Project:  
**415 CUMBERLAND AVENUE**  
 PORTLAND, MAINE

Scale: 1/8" = 1'-0"  
 Date: 12 April 2018  
**ELEVATIONS**

**A2.01**

1 | CUMBERLAND AVENUE ELEVATION
1/8" = 1'-0"

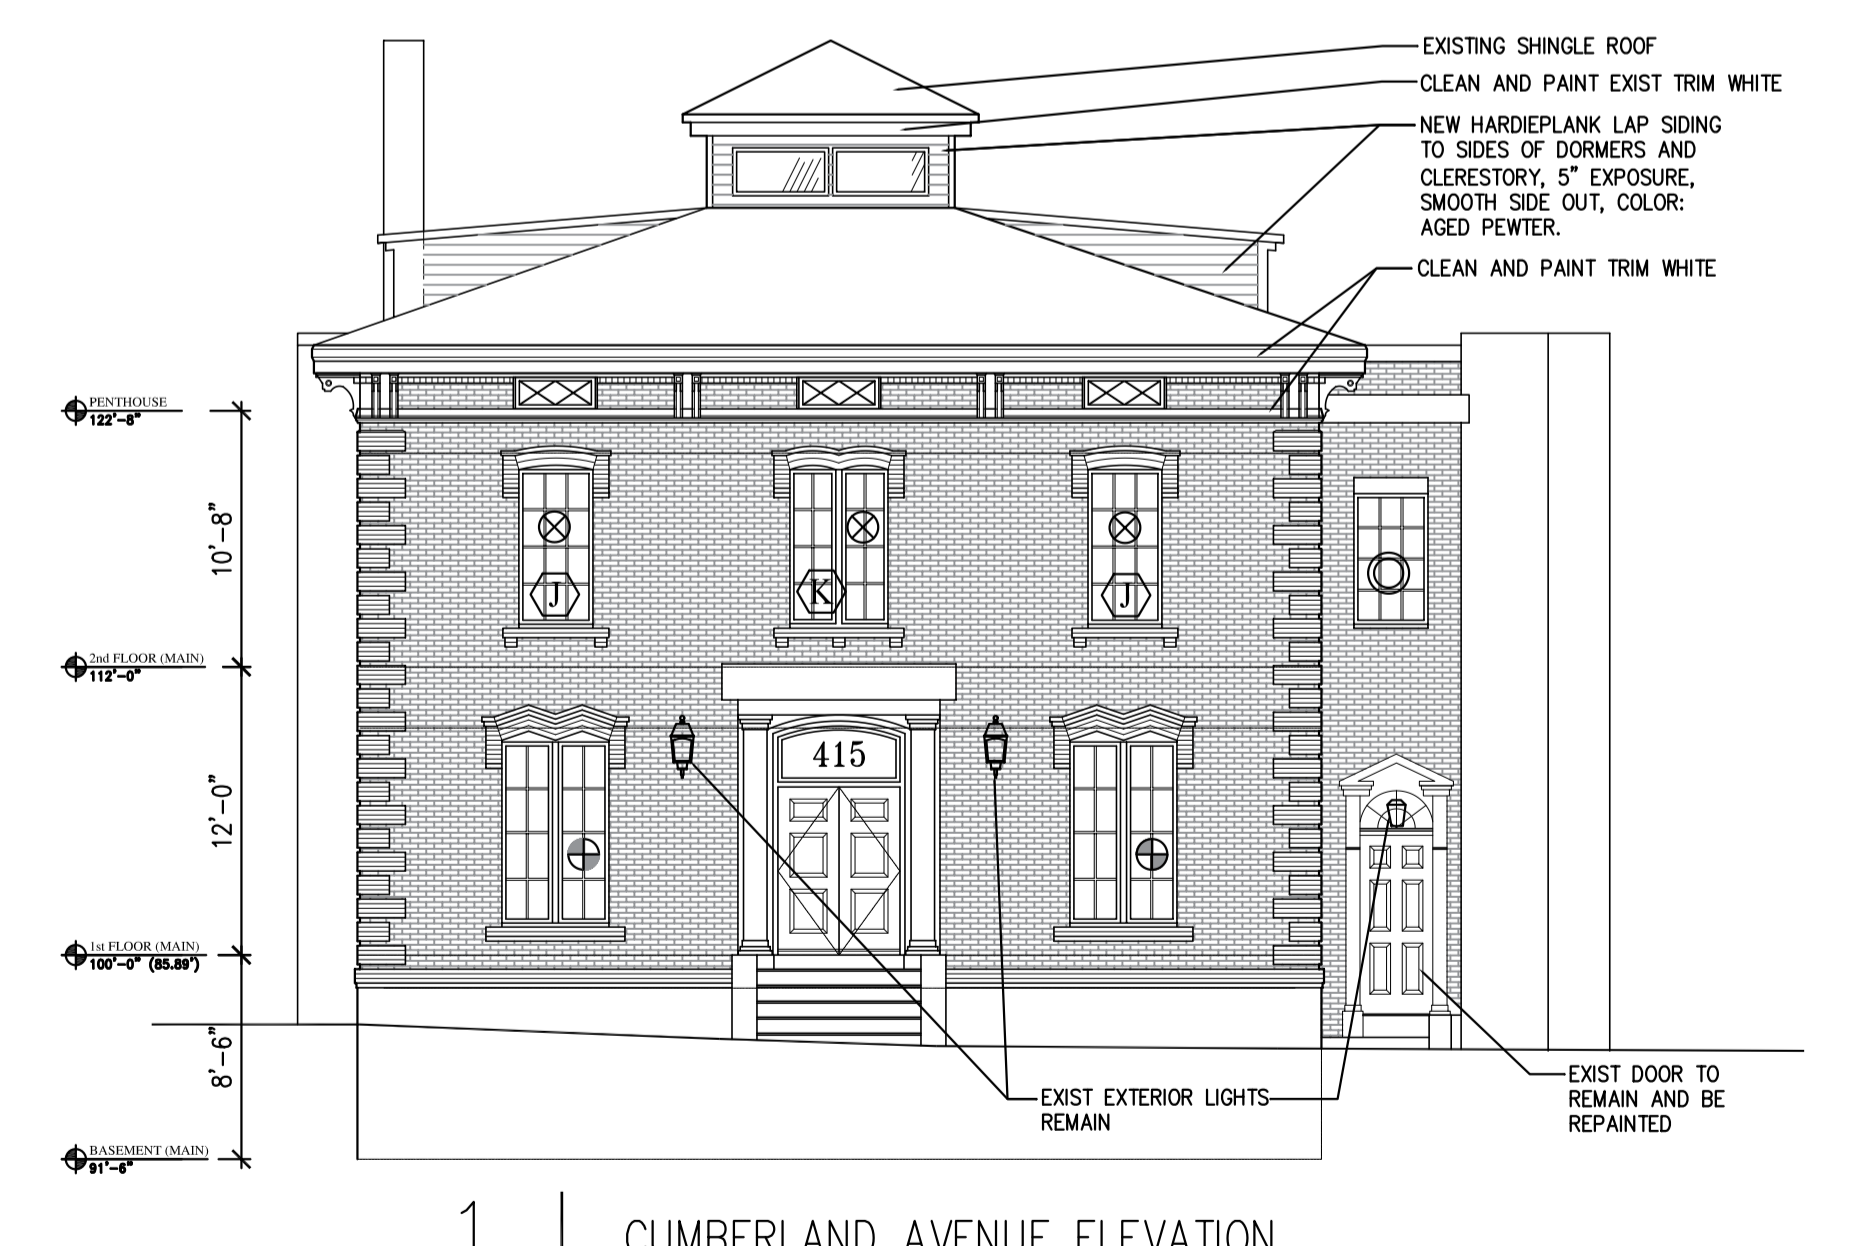
: SHOULD BE ALUMINUM CLAD WINDOW, ALUMINUM FINISHED TO MATCH SIDING (CLOSE IN COLOR).  
 (x 12) REMOVE GRILLE/GRIDS (MAKE 1/1) OR CHOOSE PRODUCT WITH EXTERIOR SIMULATED DIVIDED LITES + SPACERS, GLASS INTERIOR.

: VINYL WINDOW ACCEPTABLE, BUT REMOVE GRILLE/GRID BETWEEN THE GLASS OR CHOOSE PRODUCT WITH EXTERIOR SIMULATED DIVIDED LITES + GLASS INTERIOR SPACERS.
